**Re: Dutch Brothers Coffee – 2131 Gibson Blvd SE  
Erosion and Sediment Control Plan  
Engineer's Stamp Date 12/9/2022 (M15E021C)**

Based upon the information provided in your submittal received on 12/09/2022, the above referenced ESC Plan cannot be approved until the following comments are addressed.

Title:  
EROSION AND SEDIMENT CONTROL PLAN  
SWC GIBSON BLVD AND YALE BLVD  
ALBUQUERQUE, NM 87121

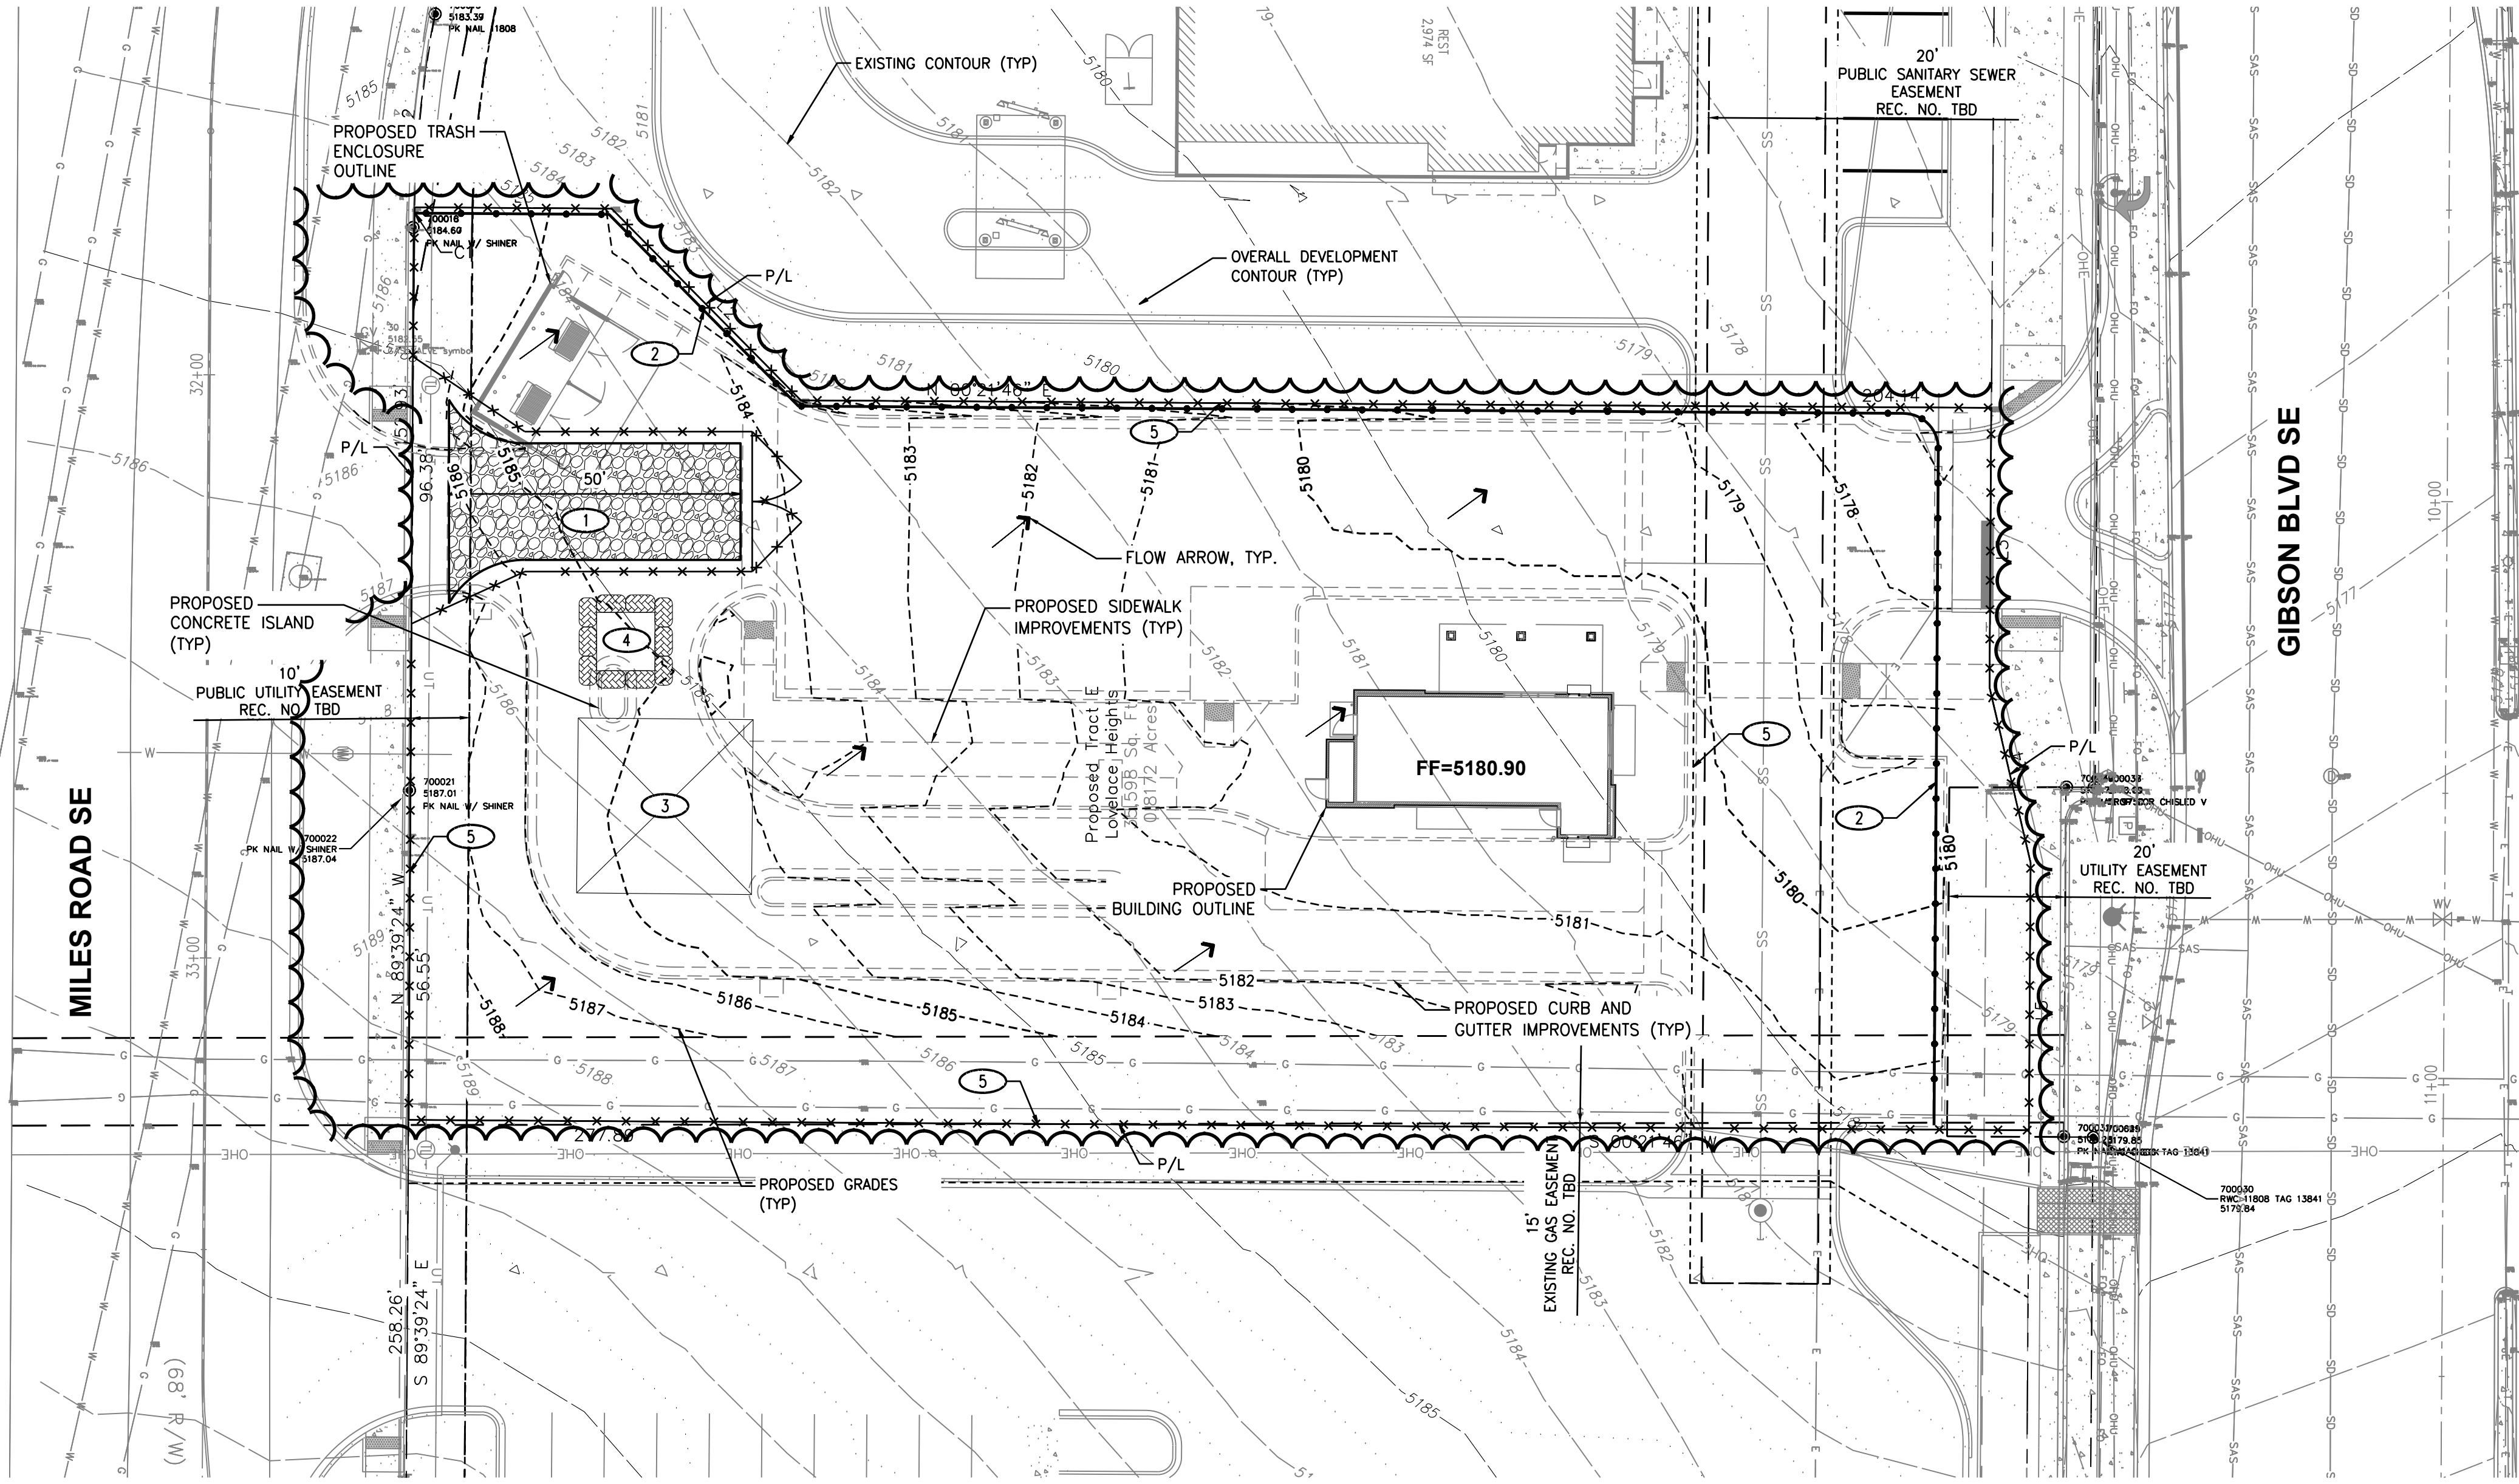
1. The ESC Plan can't be approved until after Hydrology approves the G&D Plan. The existing and proposed grades must be shown on the ESC Plan, and they must agree with the Grading Plan approved by Hydrology (CGP7.2.4.b.ii).

2. Show all structures on the ESC Plan including the building, sidewalk, and asphalt.
3. This site is part of a "Common Plan of Development or Sale" that exceeds 5 acres, so permit coverage is required even if the site is less than 1 acre and waivers are not available. The ESC Plan can't be approved for Grading or Building Permit until the property owner's NOI has been reviewed and approved by City Stormwater Quality per Albuquerque Code § 14-5-2-11(a). The NOI must be in the SWPPP and available onsite (CGP7.3).

4. Describe the nature and extent of construction activities (CGP 7.2.2.). Include a description and project schedule per CGP 7.2.3.f starting with installation of the BMPs, posting a sign, and demolition of existing AC, through final stabilization, removal of BMPs, and filing NOT.
